Our Case Number: ACP-323830-25

Re: Proposed flood relief scheme
in Mountmellick, County Laois

Mountmellick Flood Relief Scheme

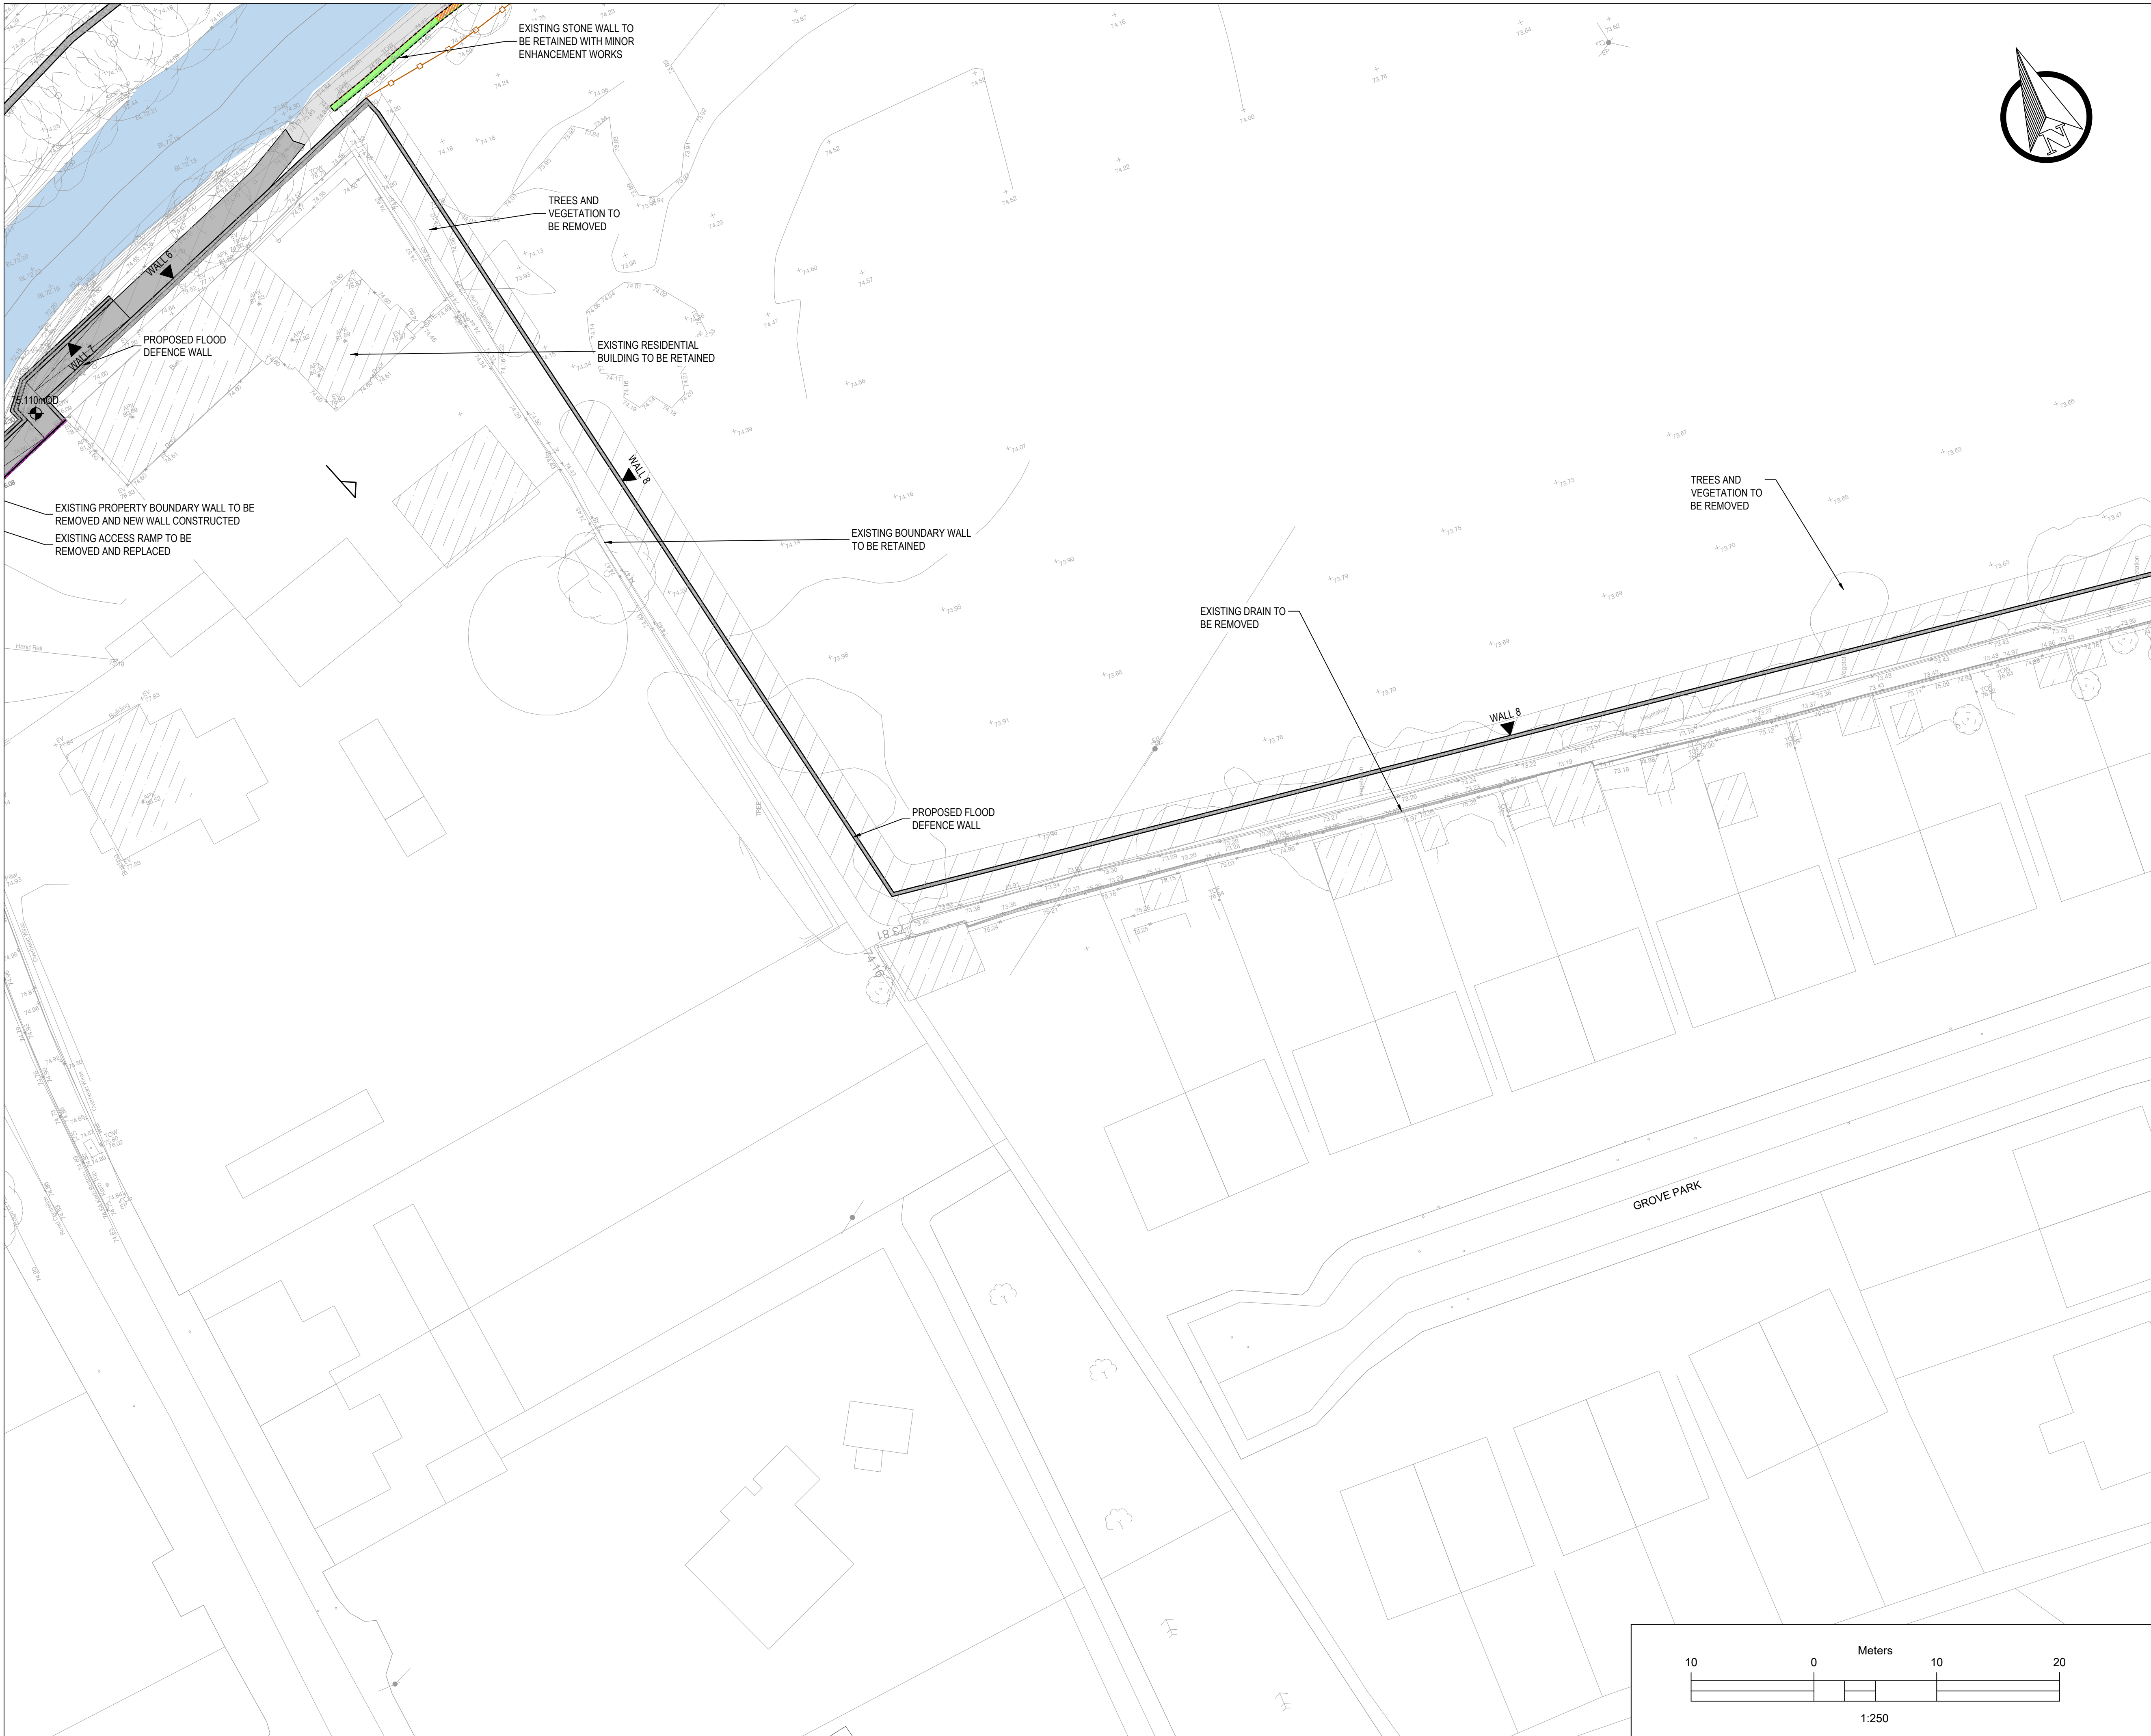
At present two conflicts are identified. One at the MDA end of the embankment and the other at the Manor Court end. I have provided drawings that show the two conflicts in relation to our development scheme plan. If some small changes were made to the positioning of the embankment it would facilitate the construction of this roadway.

1. The embankment is moved 5 meters as illustrated on the drawings,
2. The fenced turning area is reconfigured and,
3. The position of the overpass embankment is altered.
